**COFFS HARBOUR HOSPITAL EXPANSION, 345 PACIFIC HIGHWAY, COFFS  
HARBOUR (SSD 8981)**

On 2 July 2018, the Department of Planning and Environment requested the Government Architect NSW (GANSW) provide an independent design review of application SSD 8981 for the Coffs Harbour Hospital Expansion. In conducting the review, GANSW has considered the EIS submitted by Geolink on 18 June 2018 and its appendices. A design review also took place on 1 August 2018 attended by Health Infrastructure, MSJ Architects and an independent hospital design expert.

DRAWING NAME
WAYFINDING

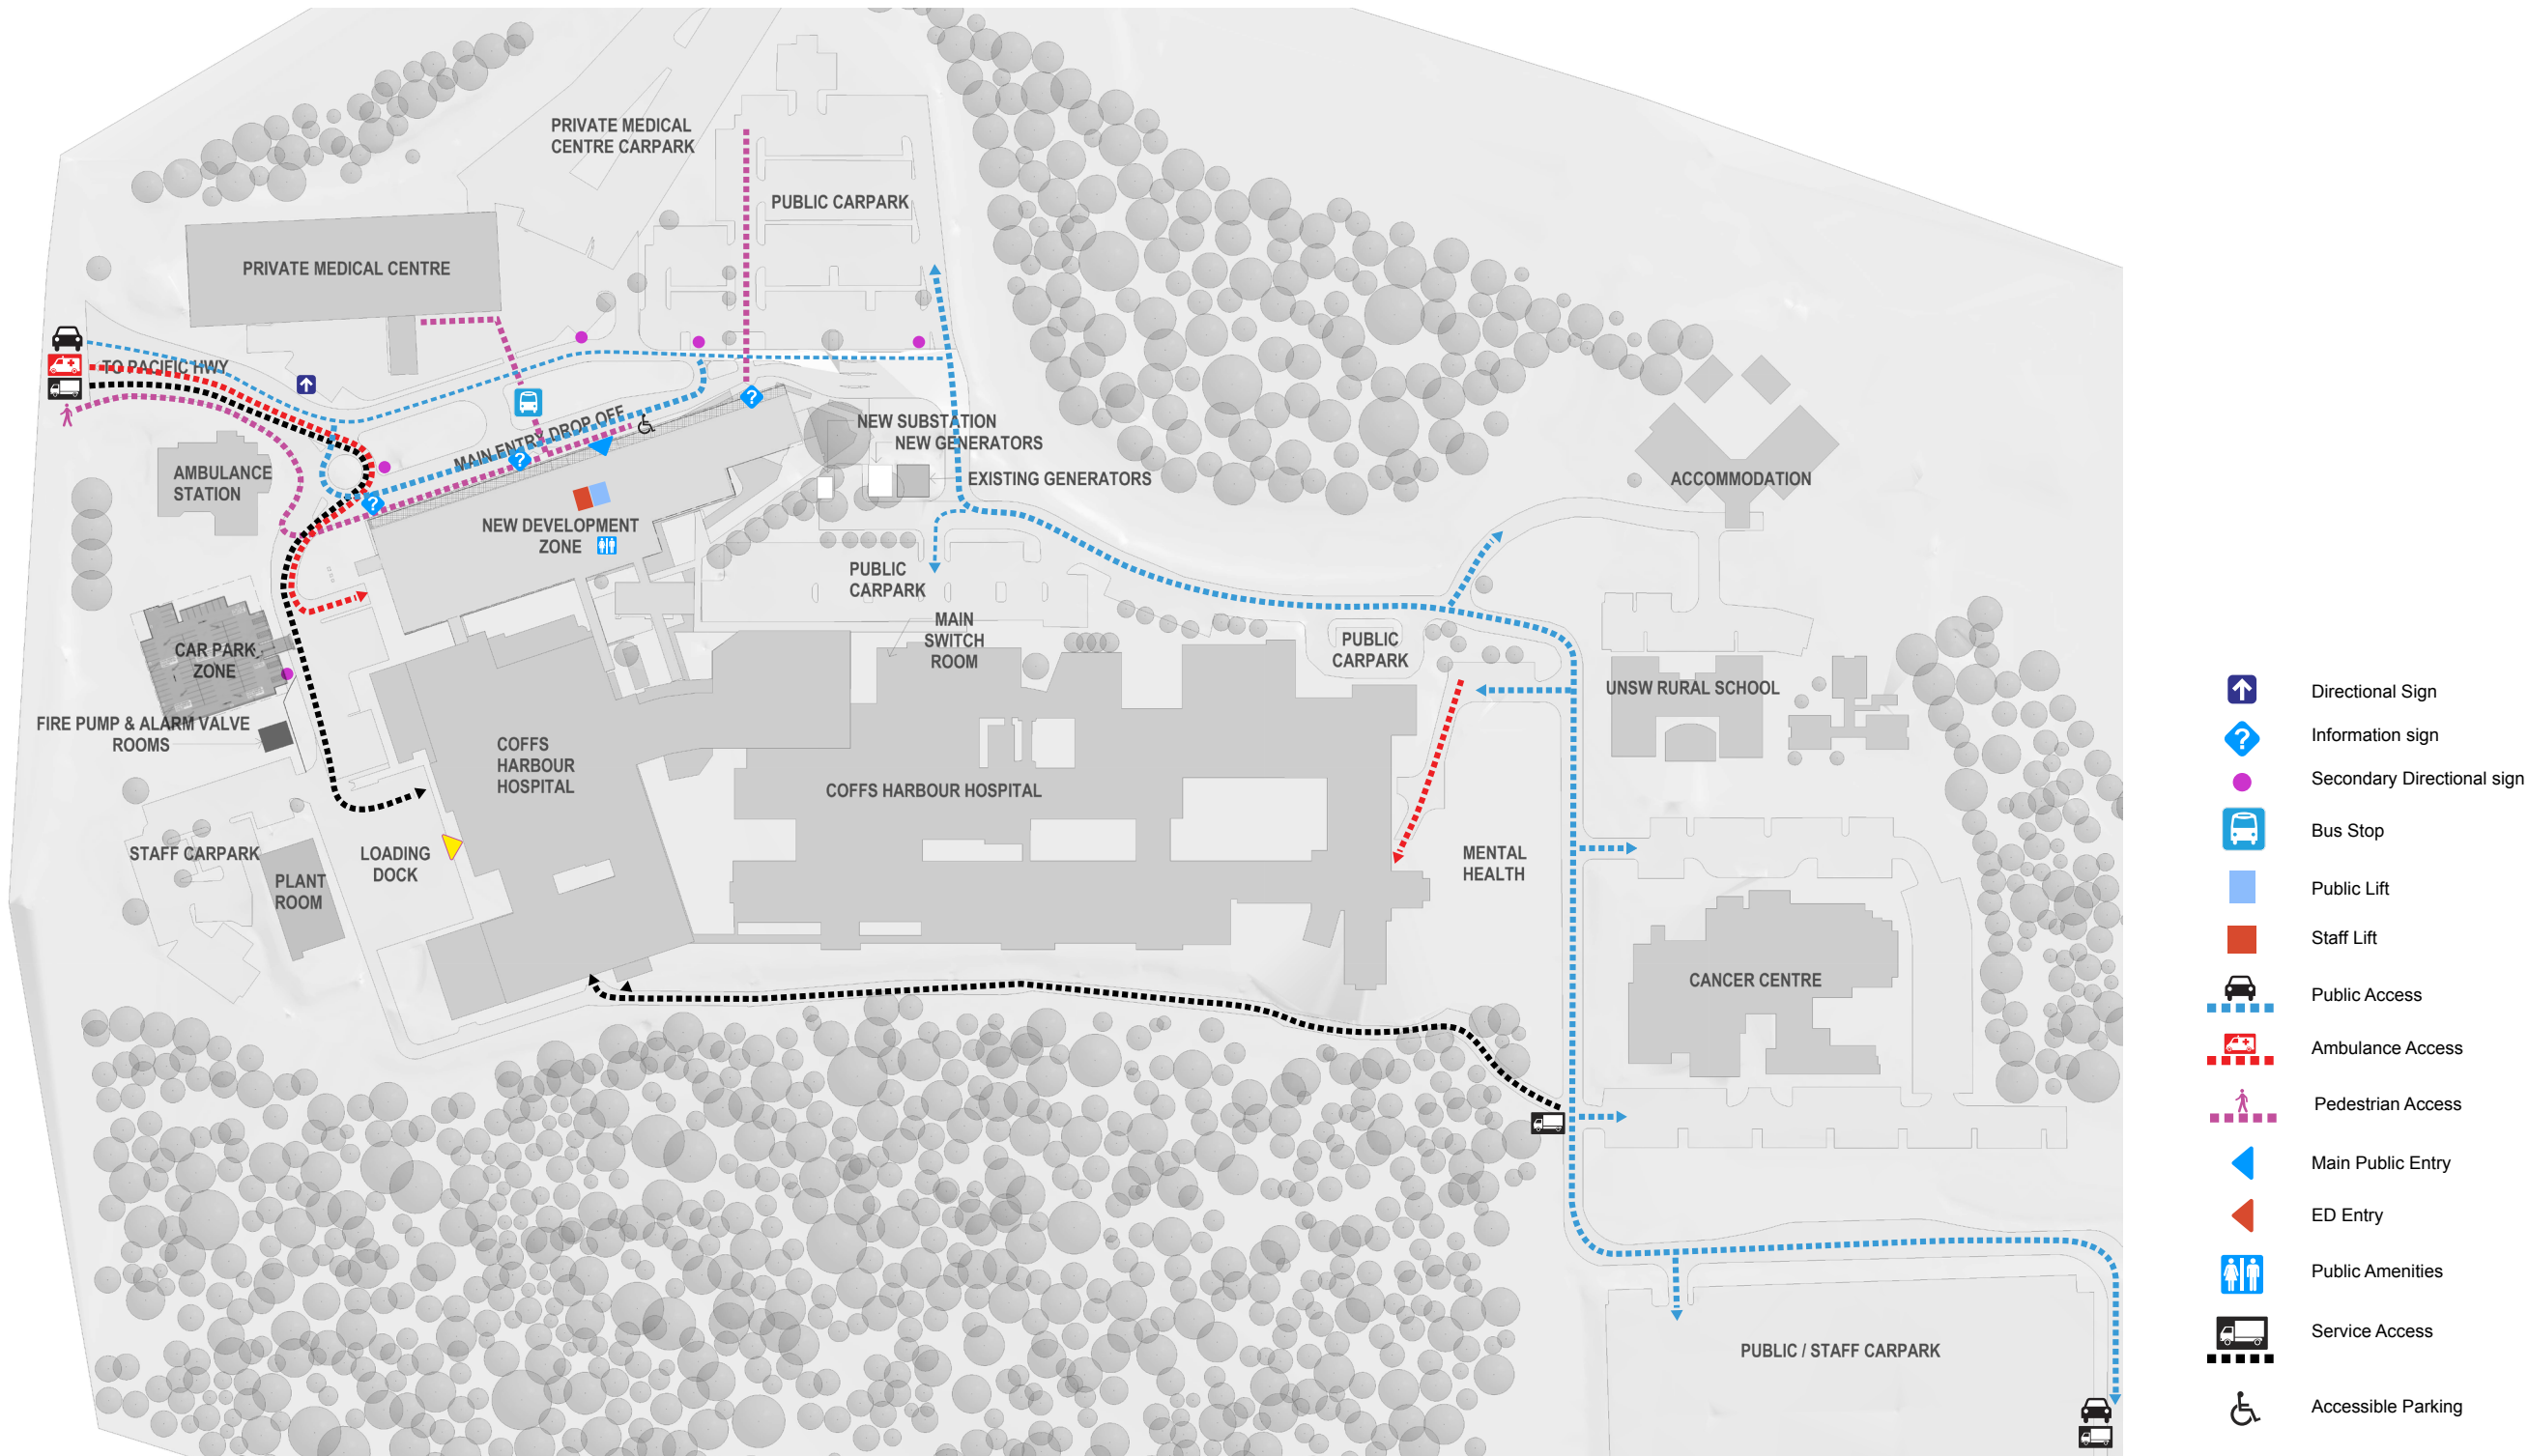
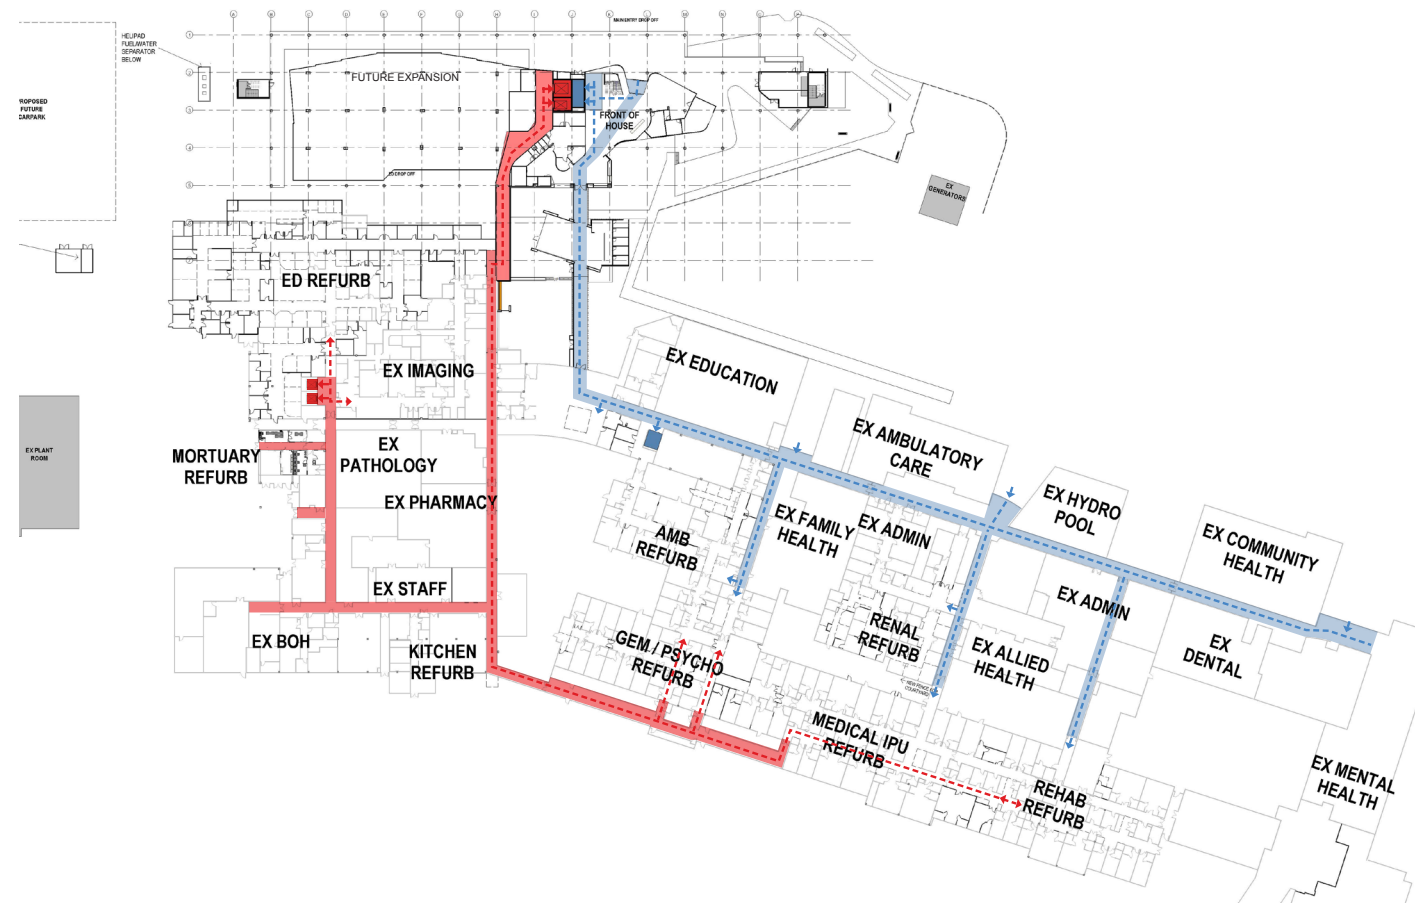
It is understood that the area indicated at the western end of the ground floor is for future Emergency Department expansion. The way in which this space is articulated and used prior to expansion should be made clear. The staff travel corridor may isolate the front of house area from the future Emergency Department. We recommend the ground floor planning strategy be reviewed to verify wayfinding is intuitive and space is generously provided.

ELEVATIONS

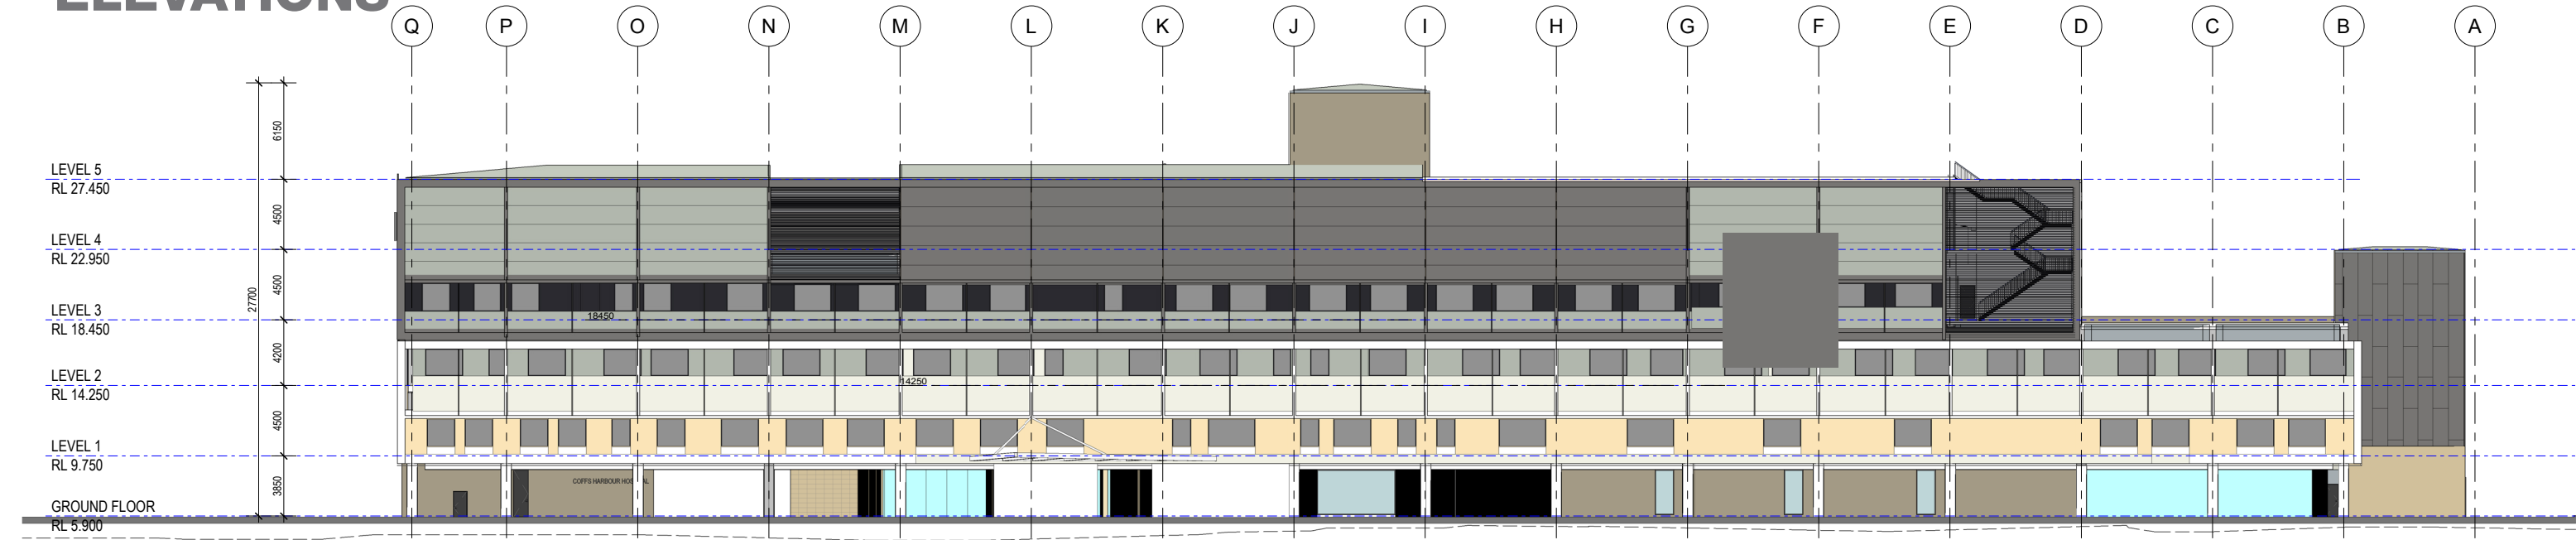
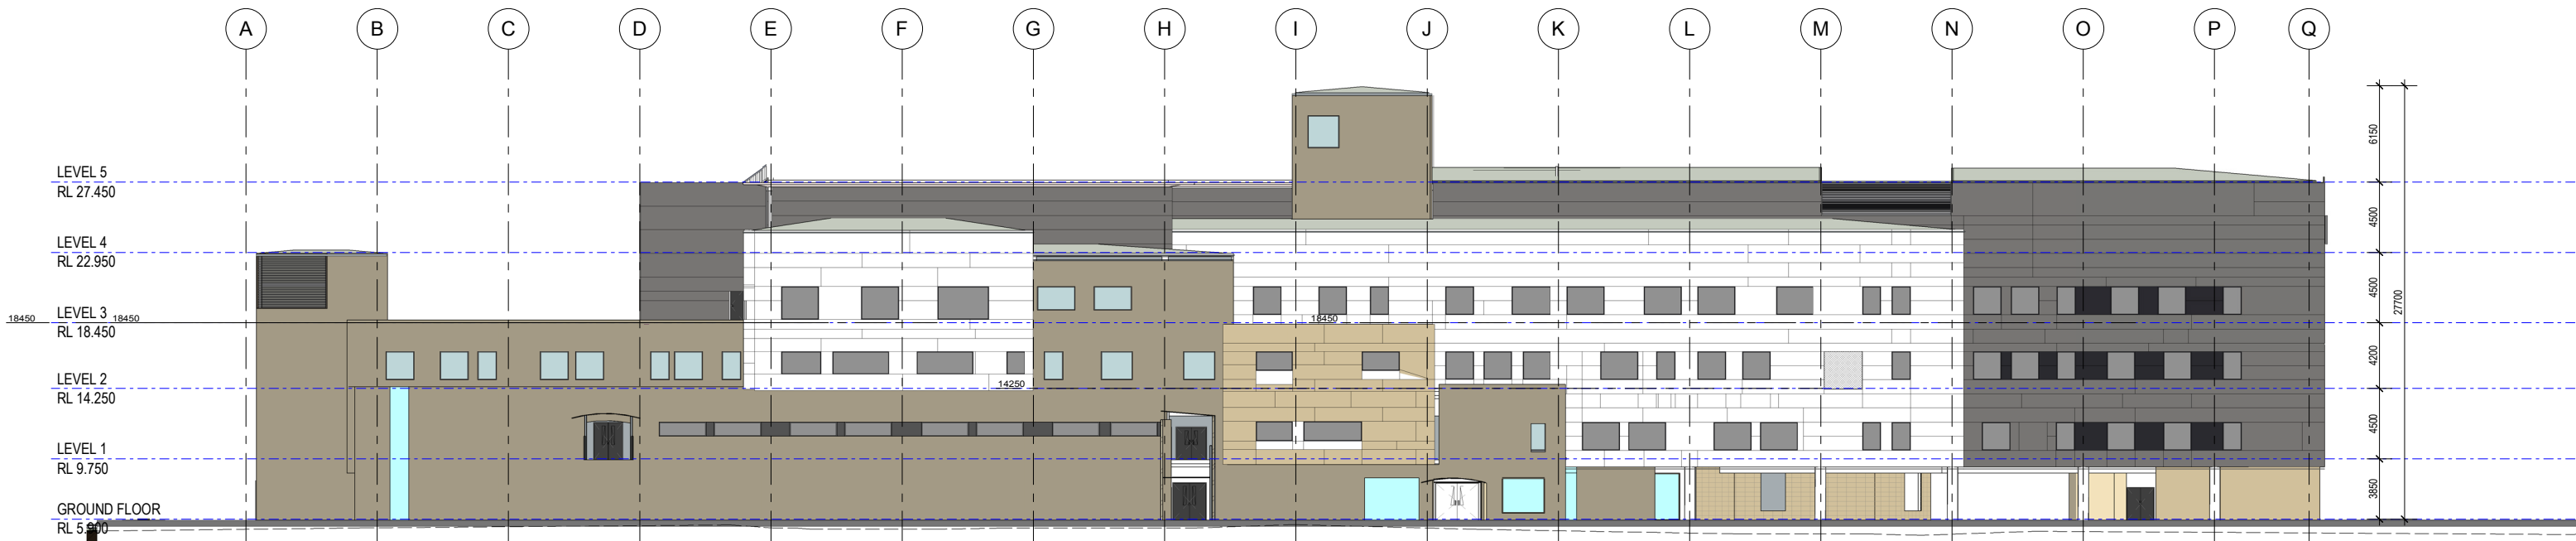
The form and articulation of the proposed building façade is generally supported for its simple expression and provision of solar shading to windows. The central part of the plant room level façade presents as an unbroken expanse of cladding and could be better articulated to integrate with the overall façade composition. The western stair core might also be better expressed, particularly by picking up the horizontal datum line formed by the undercroft.
